Reference No:	2025/62/90286/E
Site Address:	185, Headfield Road, Savile Town, Dewsbury, WF12 9JJ
Description:	Erection of two storey side and rear extensions and front and rear dormers
Recommending Officer:	Jennifer Booth

DECISION – REFUSED

OFFICER REPORT

GROUND FLOOR

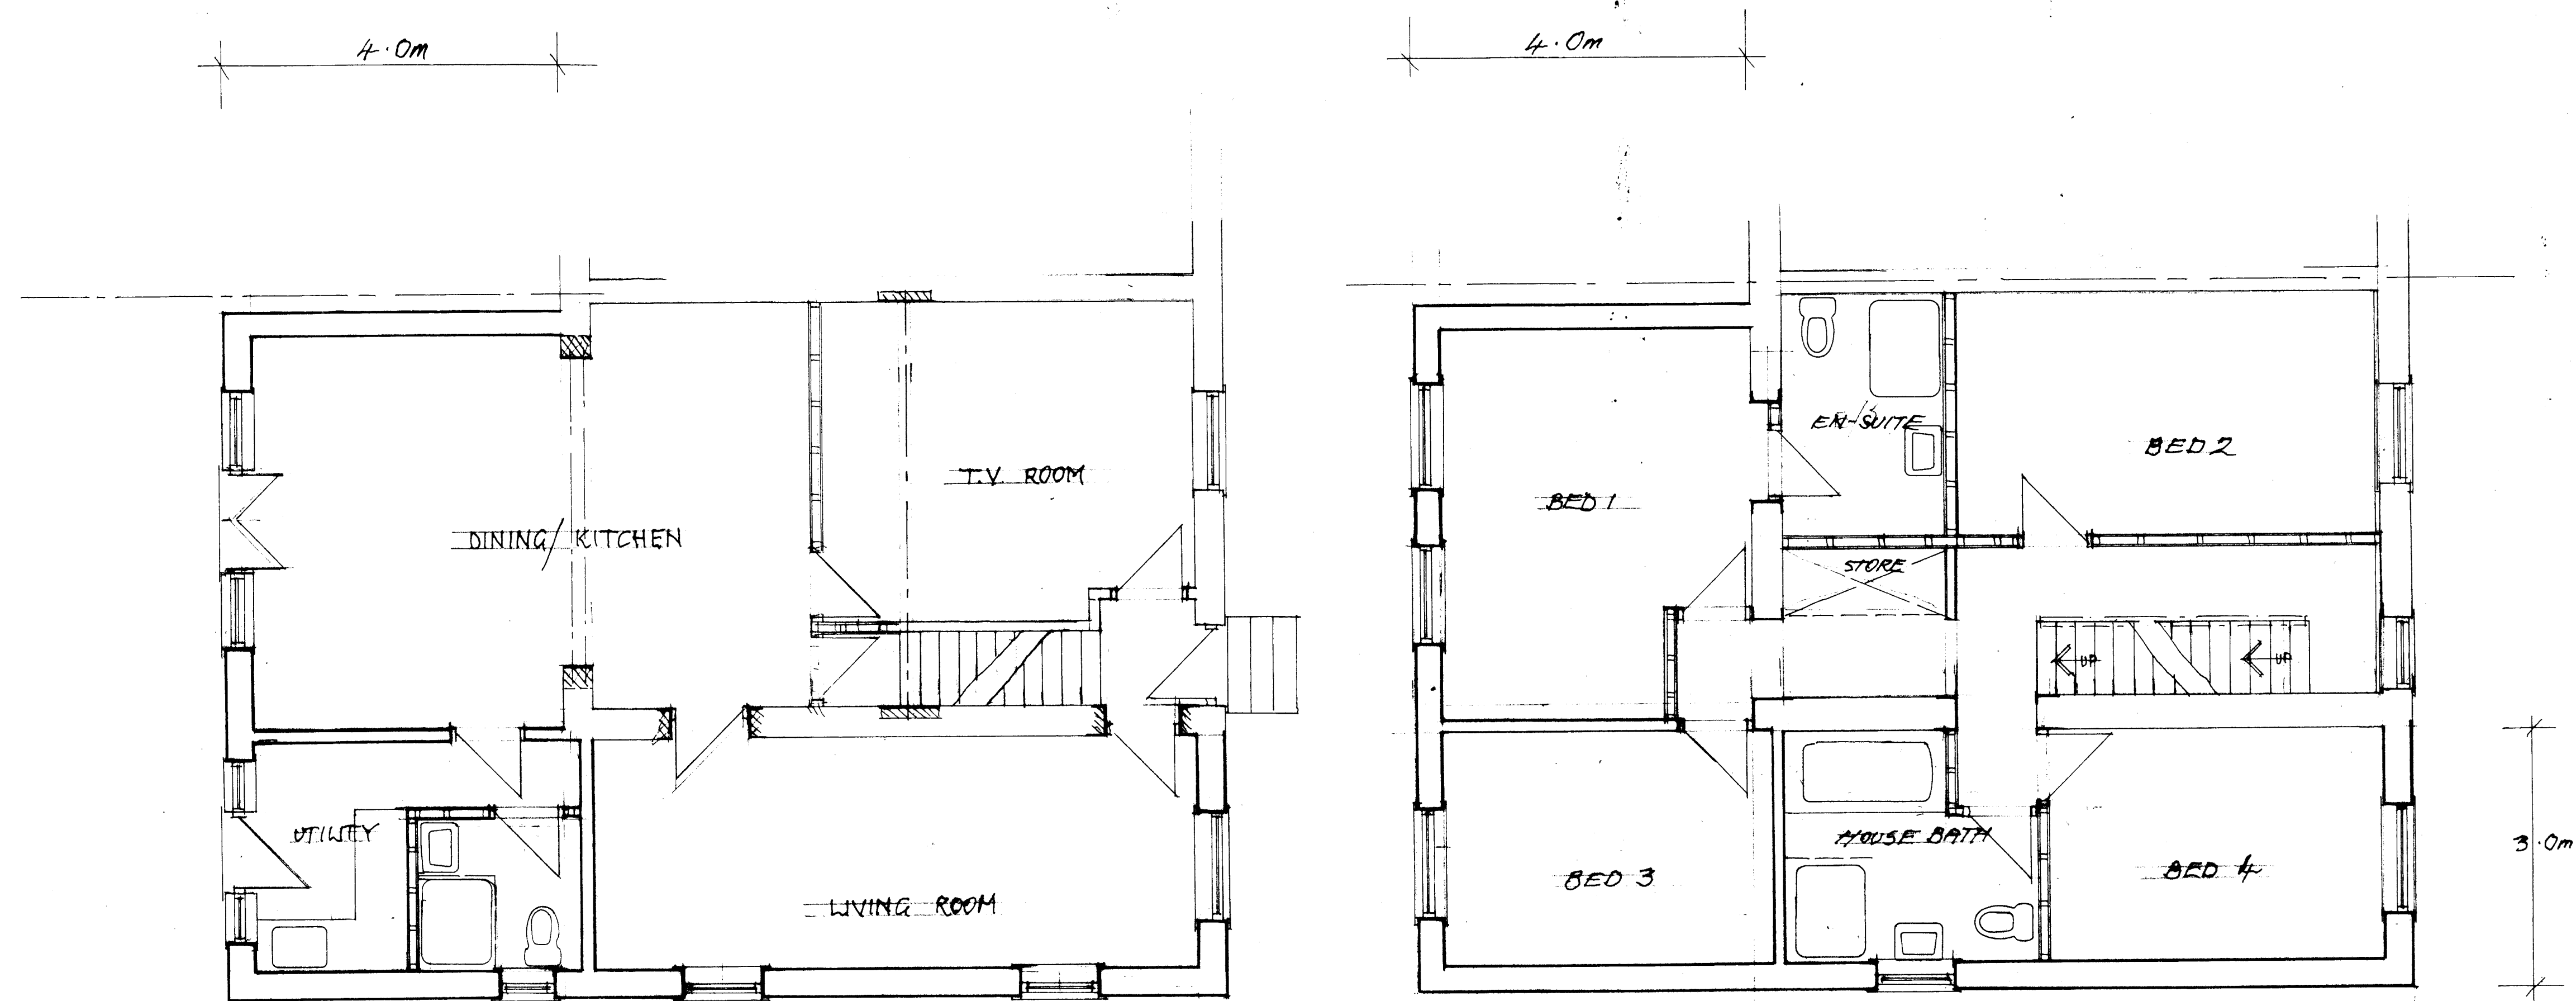
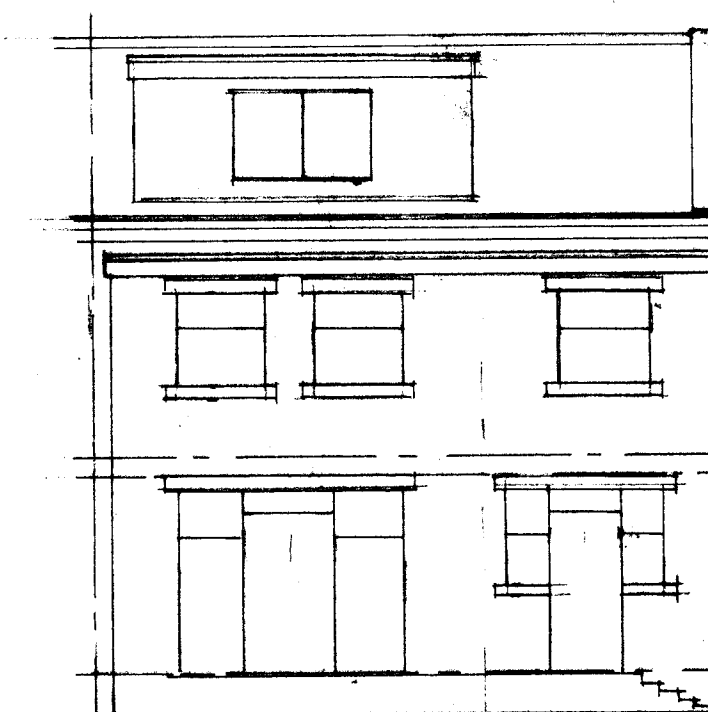
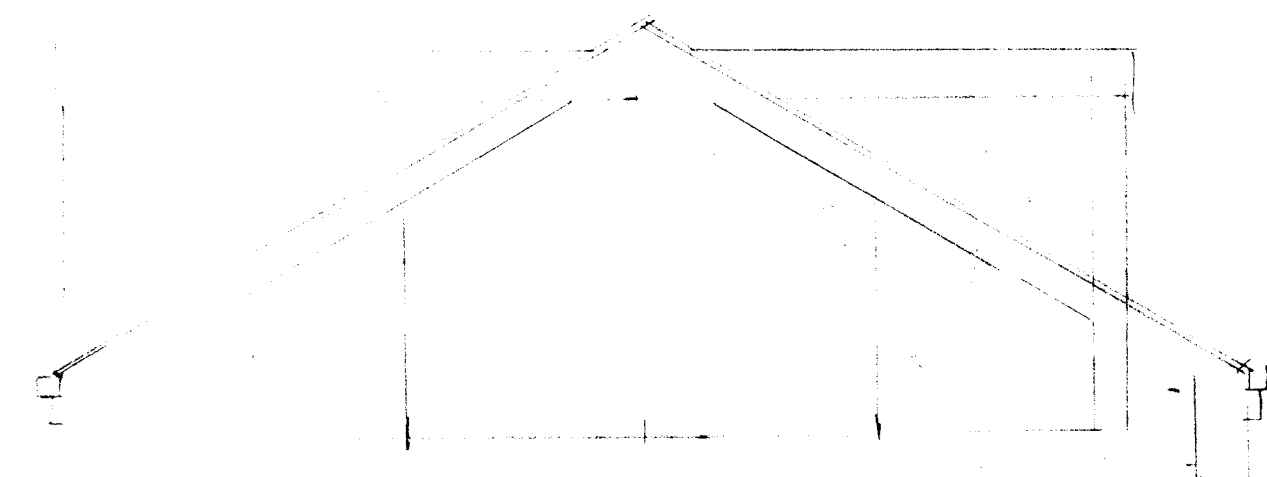
The 4m projection proposed would appear large on the rear of the modest terraced property and out of scale with the host property and the row of dwellings. Furthermore, the use of a flat roof form represents poor design. There are no extensions in this group of properties and the extension would therefore also be out of character with the area. The rear extension, despite the use of stone for the walling, would not be considered to be acceptable in terms of visual amenity.

The two storey rear extension proposed with its protection of four metres along the shared boundary with the adjoining property would result in an overbearing and oppressive impact on the modest amenity space and rear windows of the adjoining property.

REAR ELEVATION

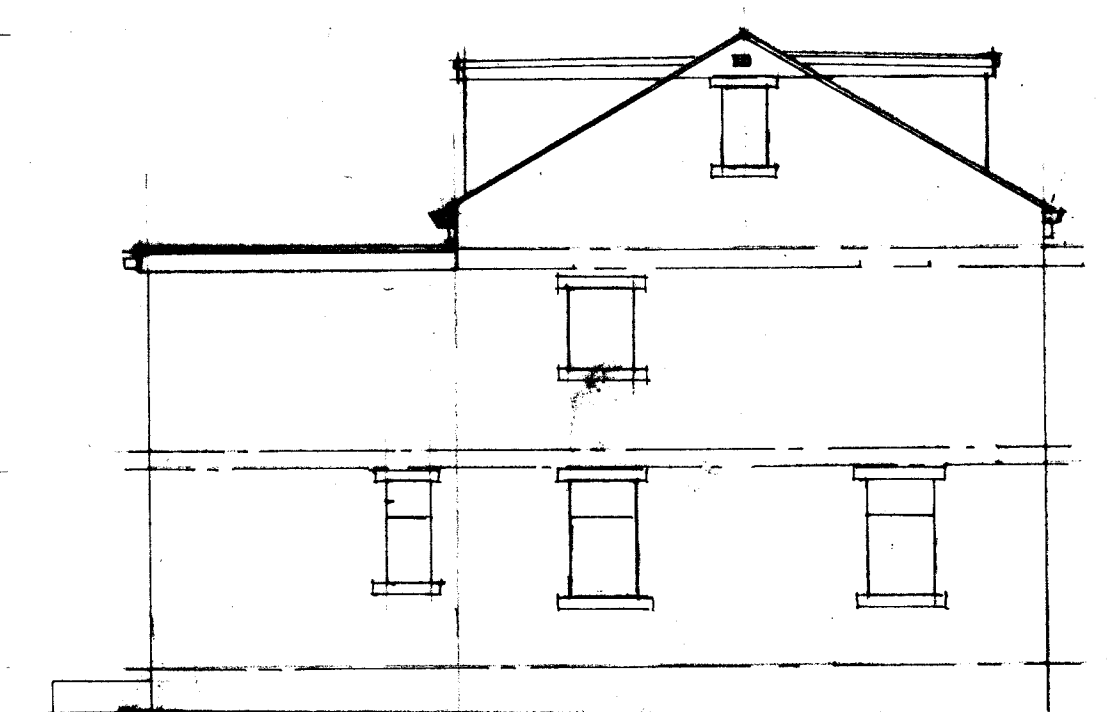
The side and rear extension would however reduce the space and windows proposed in the rear elevation would overlook the amenity space of the neighbouring property to the rear.

The proposed rear extension, by reason of the design and scale in particular the four metre projection with the flat roof form would not represent good design and would form an incongruous feature relative to the host property. To permit the proposals would be country to Policy LP24, KDP1 & KDP2 of the House Extensions & Alterations SPD and Chapter 12 of the National Planning Policy Framework.

The proposed rear extension, by reason of the projection and position along the shared boundary, would result in an overbearing and oppressive impact on the rear windows and amenity space of the adjoining 187 Headfield Road. To permit the proposals would be country to Policy LP24, KDP5 of the House Extensions & Alterations SPD and Chapter 12 of the National Planning Policy Framework.

The proposed side & rear extension, by reason of the projection and position close to the boundary with the neighbouring property to the rear, would result in overlooking of the amenity space of the neighbouring 197 Headfield Road. To permit the proposals would be country to Policy LP24, KDP3 of the House Extensions & Alterations SPD and Chapter 12 of the National Planning Policy Framework.

FRONT ELEVATION

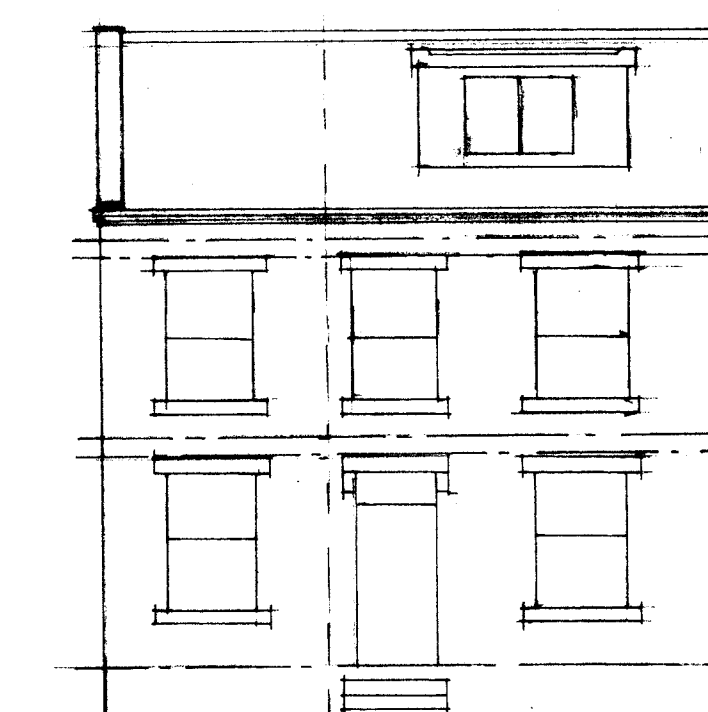
The scale of the front dormer is considered acceptable as it is set up from the eaves, down from the apex and in from the sides. Furthermore, there are other such dormers in the row of properties. The dormer would be clad with horizontal timber boarding, similar to the other dormer in the row. As such, the front dormer is considered to be acceptable in terms of visual amenity.

ATTIC

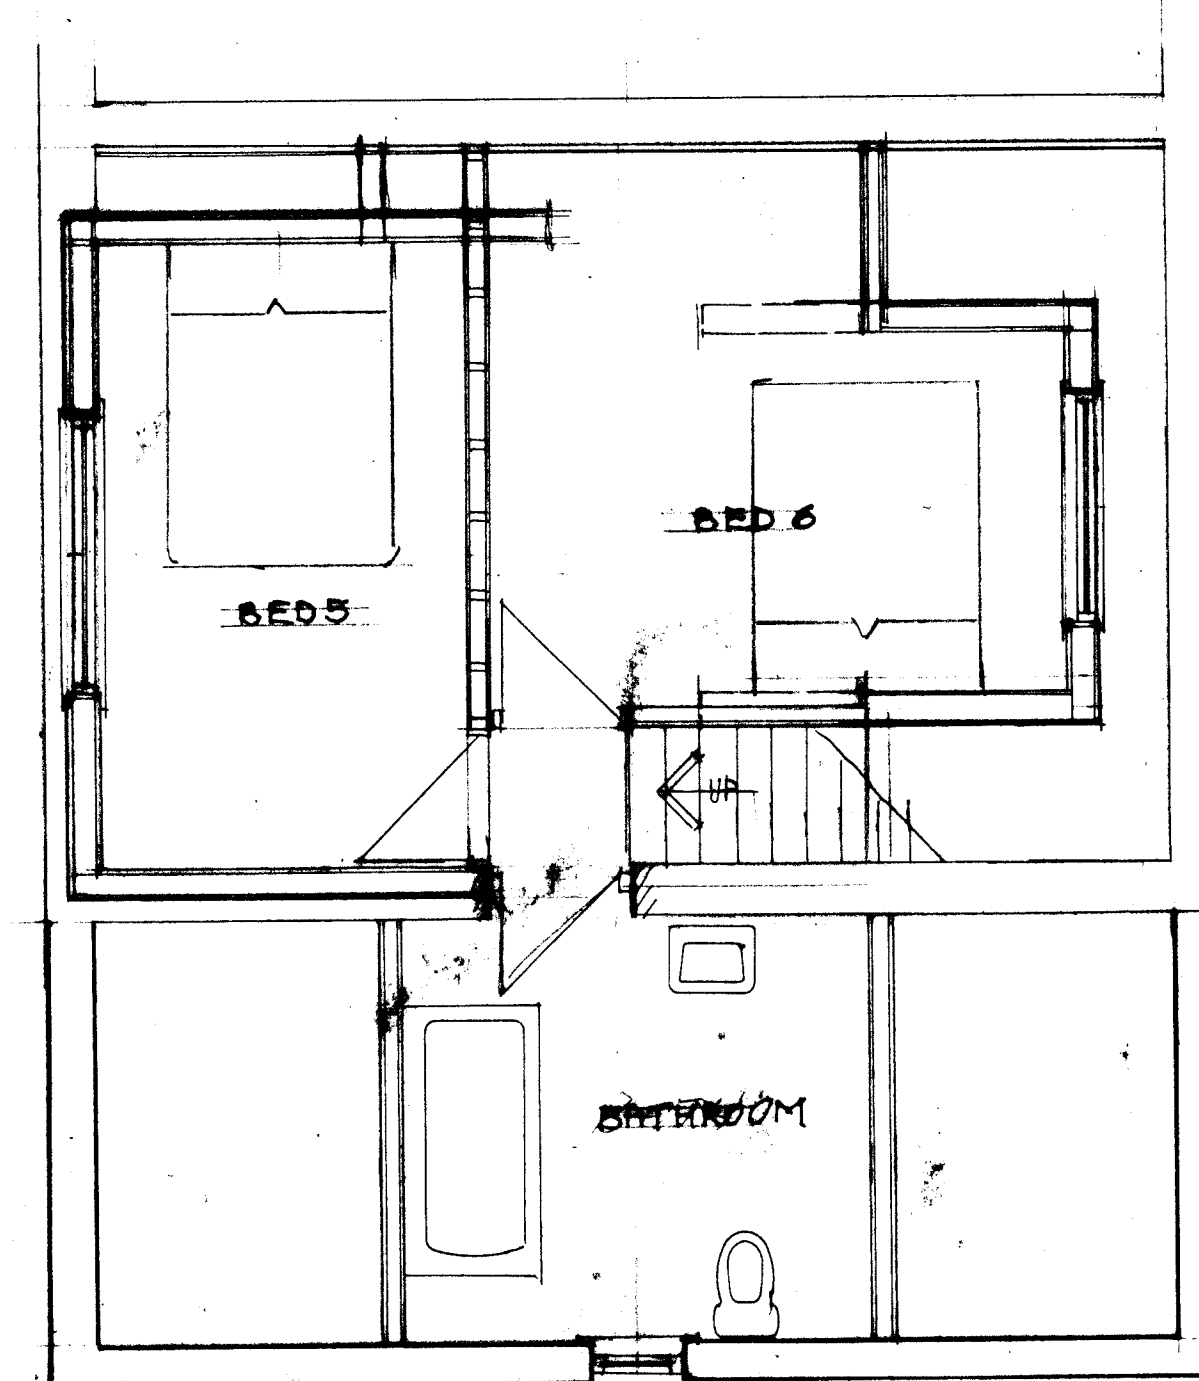
The rear dormer would be large in terms of its size and scale relative to the host building. However, it would still be comparable to the other dormer in the row. The materials proposed would also include the use of horizontal timber cladding. The rear dormer is therefore considered to be acceptable in terms of visual amenity.

The proposed rear dormer extension would face onto the garden of the aforementioned property and as such could result in overlooking. However, it needs to be acknowledged that there is already a direct relationship as a result of the existing windows at first floor level and that the proposed rear dormer would be coming no closer to the shared boundary than existing. Furthermore, due to boundary treatment on site which includes tall bushes and hedges and the fact that approximately 9.00 metres will be retained between the proposed extension and the shared boundary, it is not deemed that the proposal will have a significantly detrimental impact on residential amenity. One of the windows in the extension will serve a bathroom and will therefore be obscurely glazed. This will further reduce the impact of overlooking.
